# Construction Drawings\_V2\_Comments.pdf Markup Summary

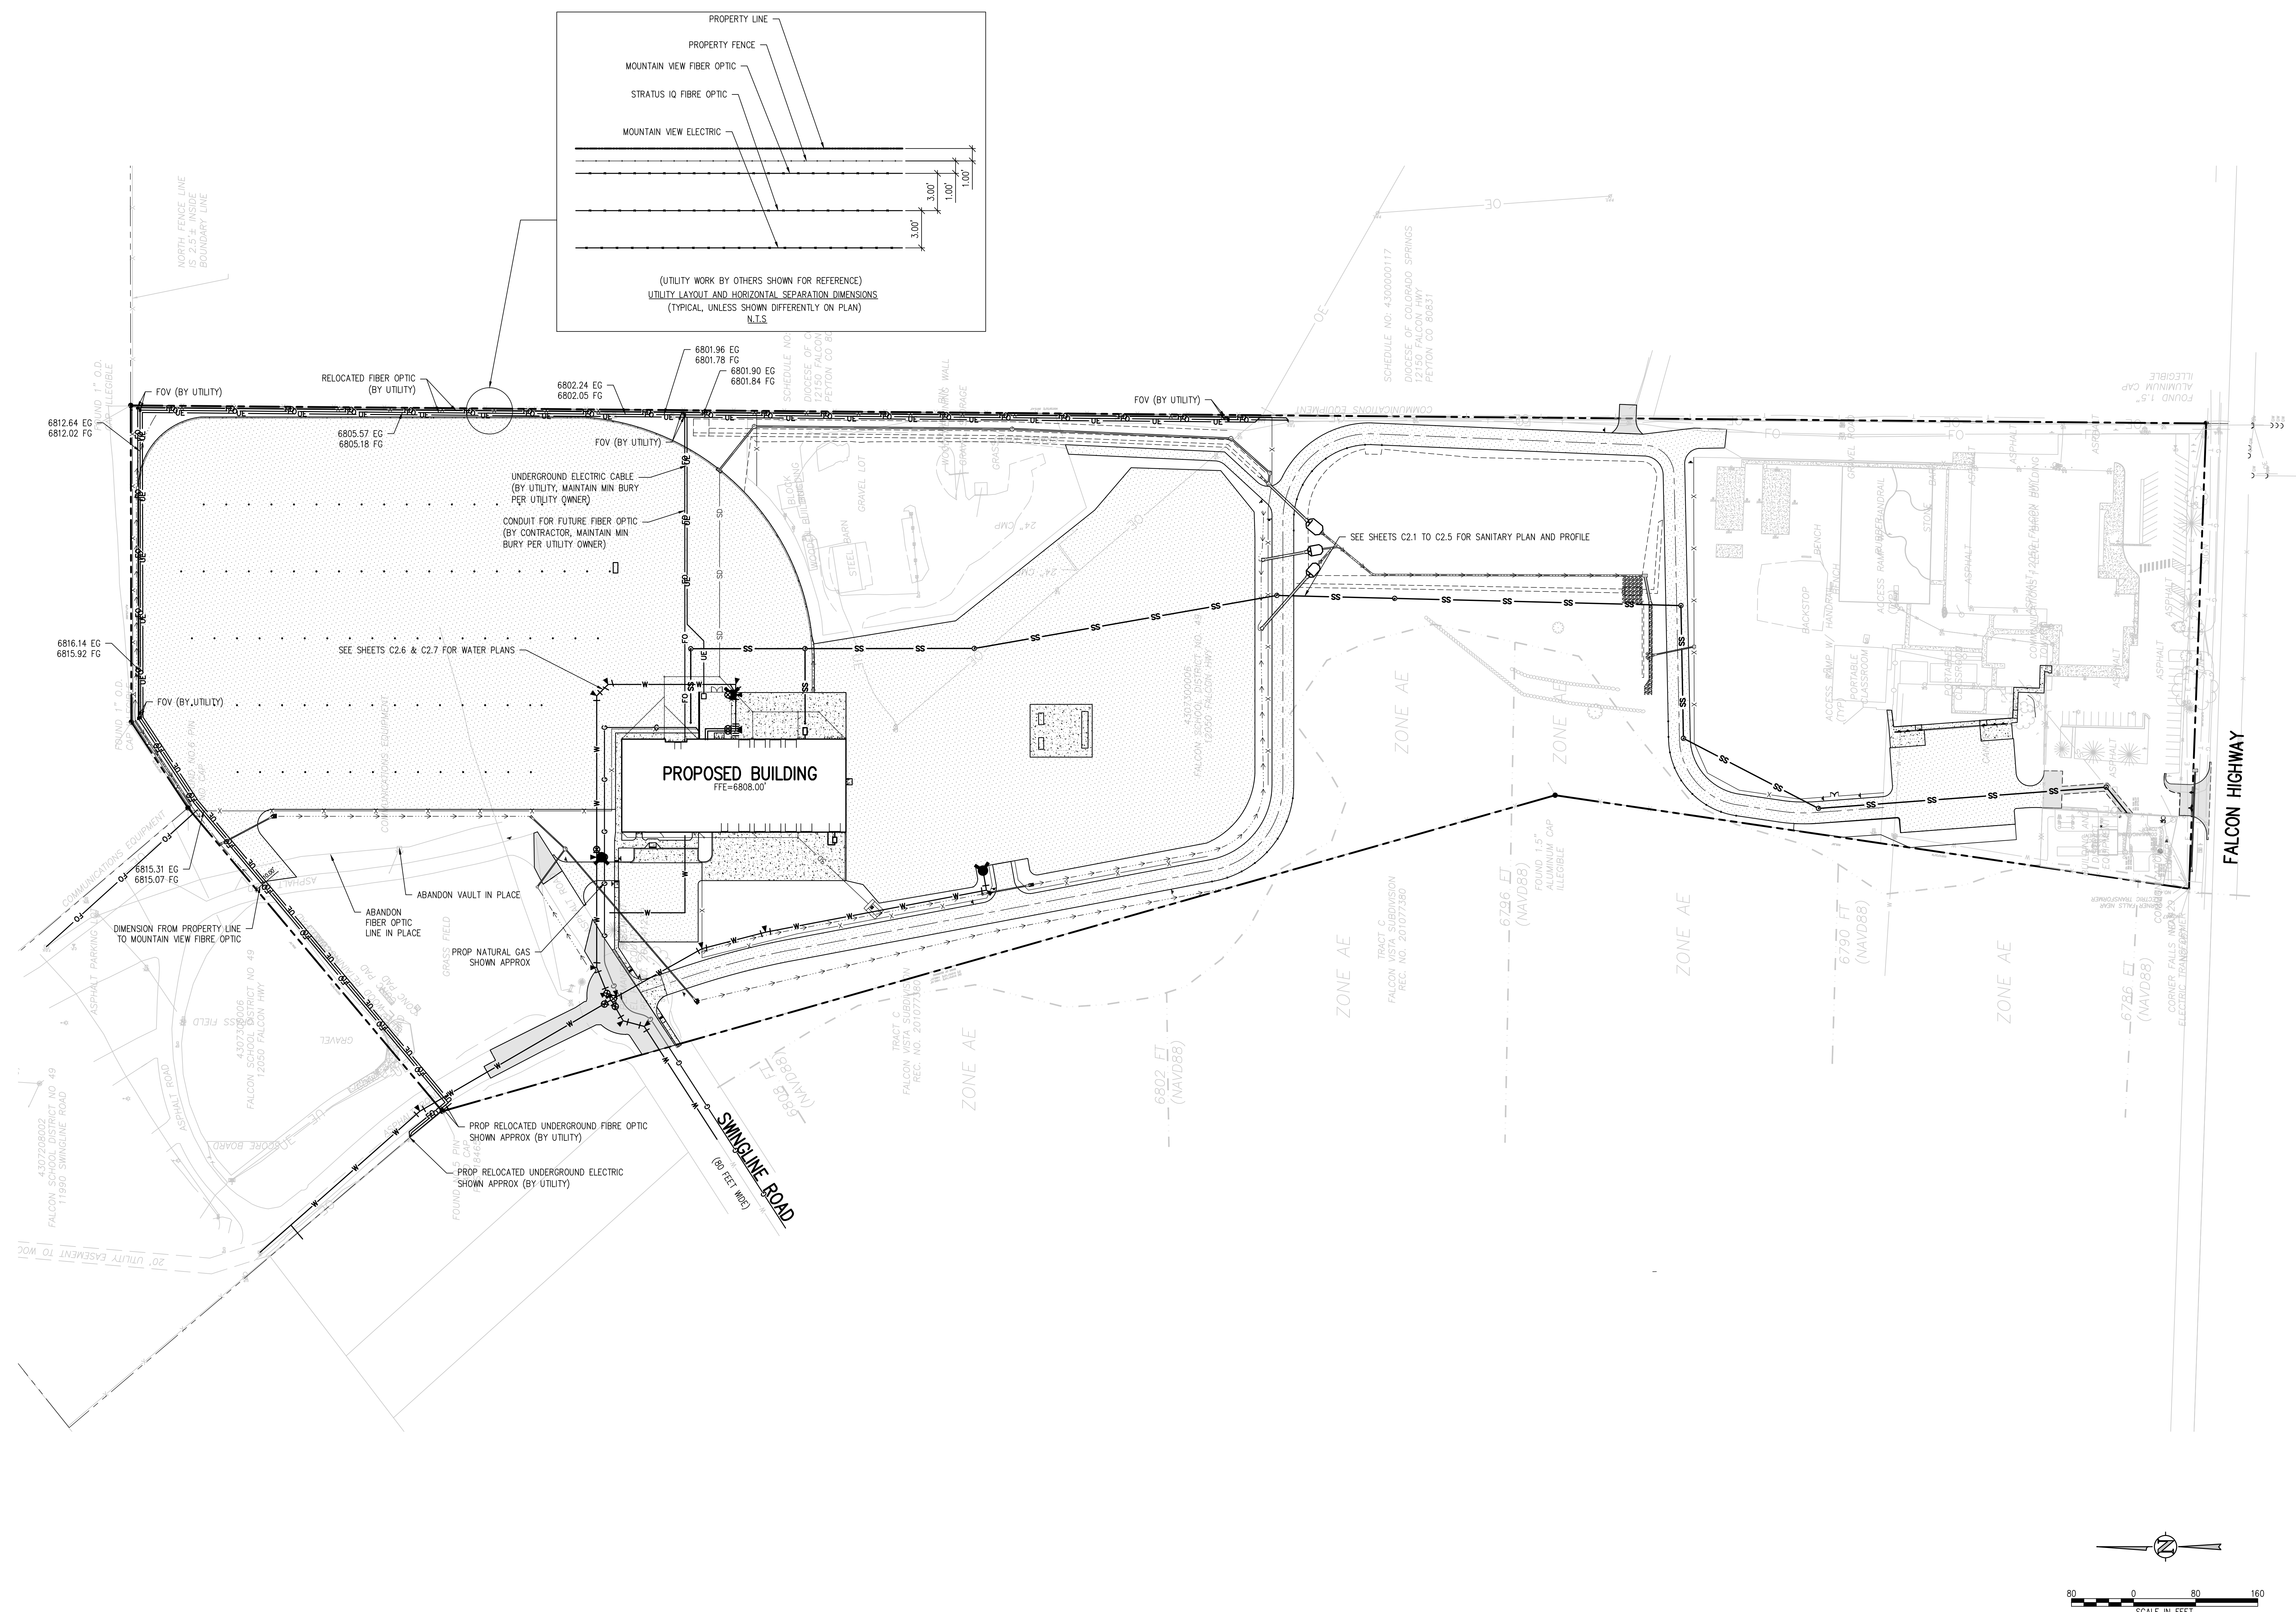
Forebay details will be reviewed on the resubmittal once the requested forebay calculation has been provided.
